Case Officer: James Kirkham

Recommendation: Approve

Applicant: Langham Holdings Ltd

Proposal: Conversion of upper floors to 3 apartments. New access in front facade

Drawing:
PROPOSED SECOND AND THIRD FLOOR PLANS

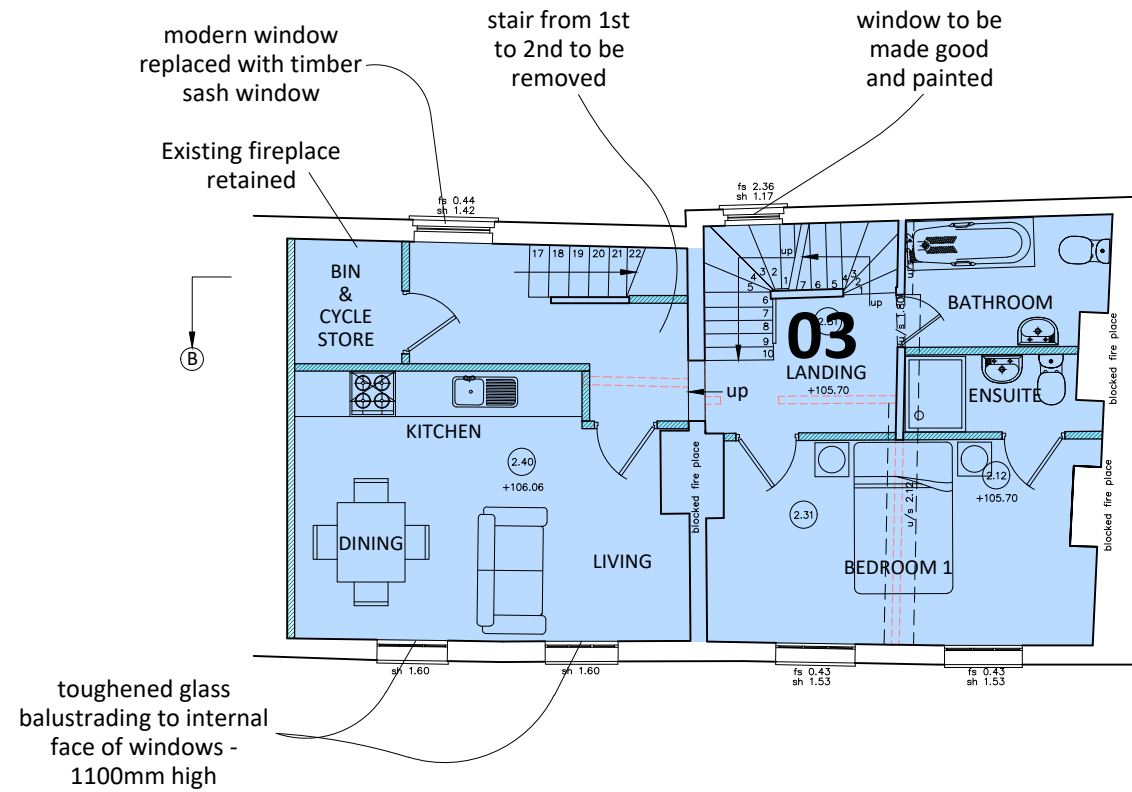
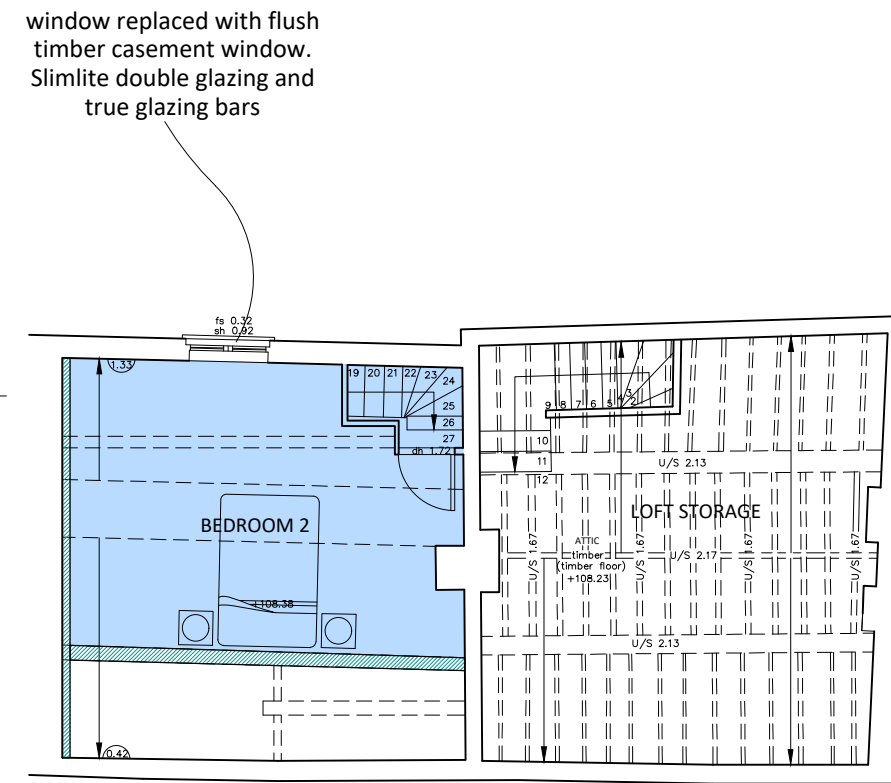
- 8.14. The proposed development seeks to reuse an existing building and has to work with the constraints of this. Whilst unit 1 has a rather limited outlook, given its relationship with existing buildings, having regard to the town centre location of the site, the listed status of the building and the reuse of the existing building this is not considered to constitute a level of harm that would outweigh the potential benefits of the scheme.

- 8.15. The units are all considered to be of a sufficient size to provide a good standard of amenity for future residents and appear to comply with the Nationally Described Space Standards for one bedroom dwellings. There is no external amenity space for the proposed residents; however, given the development is working within the constraints of the existing building and no extensions are proposed, on balance this is considered to be acceptable.

- 8.17. External bin stores are also not available given the lack of outdoor space. However, it is noted that provision is made in each flat for a storage area where bins could be kept until collection day. It is recommended that these be conditioned to be ventilated to encourage use of these spaces by residents.
- 8.18. The proposed development does not provide any parking on site. Given its scale and the town centre location, the Local Highway Authority has raised no objection to this and it is a sustainable location close to services, facilities and public transport. I therefore consider the lack of parking provision to be acceptable.

5. Prior to the first occupation of any dwelling hereby approved, full details of the ventilation systems to the internal bin stores shall be submitted to and approved in writing by the Local Planning Authority. The internal bin storage and ventilation shall be provided in accordance with the approved details prior to the first occupation of the dwellings and shall be retained as such thereafter.

Drawing:  
**EXISTING & PROPOSED NORTH EAST ELEVATIONS**  
Drawing scale: 1:100 at A3 Drawing date: JULY 2021  
Drawing no. Revision

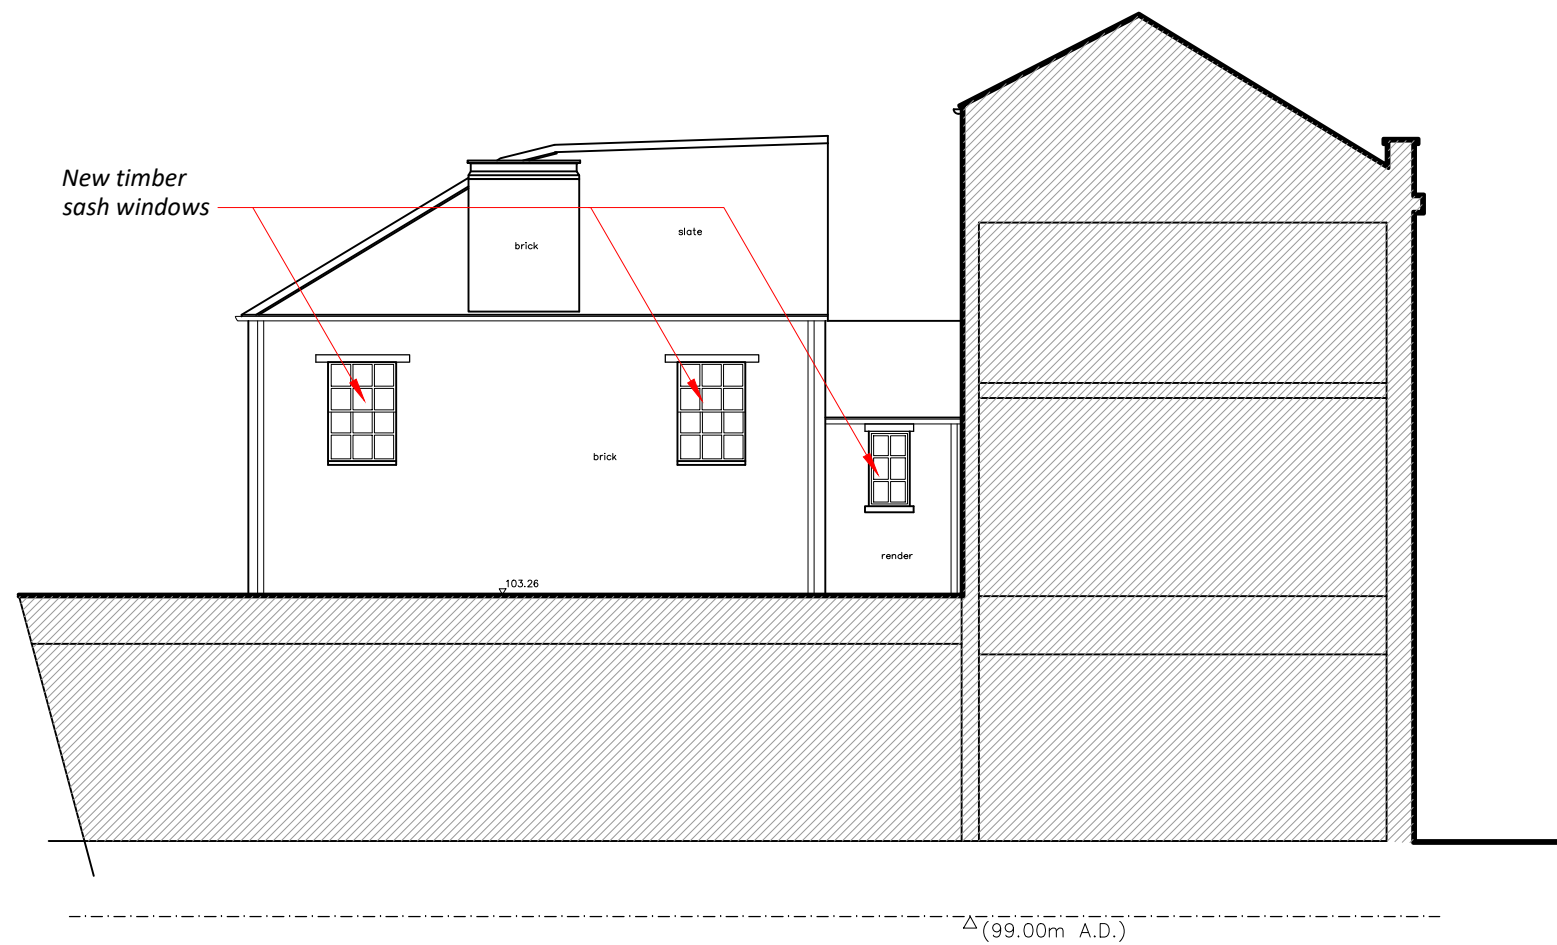
- 8.10. The external changes to the building largely relate to the replacement and additional of new windows. These include a mix of sliding sash windows and casement windows. Where windows are replaced, modern windows would be replaced with more traditional style windows. The arrangement and style of windows is considered to be acceptable subject to condition. Whilst a typical section of a timber sliding sash window has been provided with the application this does not include details of the recess of the window from the brick face or the cill or header details. Furthermore, there are no details of the timber casement windows proposed. Therefore, conditions would be required in this respect.

- Where new windows or doors are proposed full details of the doors and windows, at an appropriate scale including a cross section, cill, headers and recess detail and colour/finish, shall be submitted to and approved in writing by the Local Planning Authority.
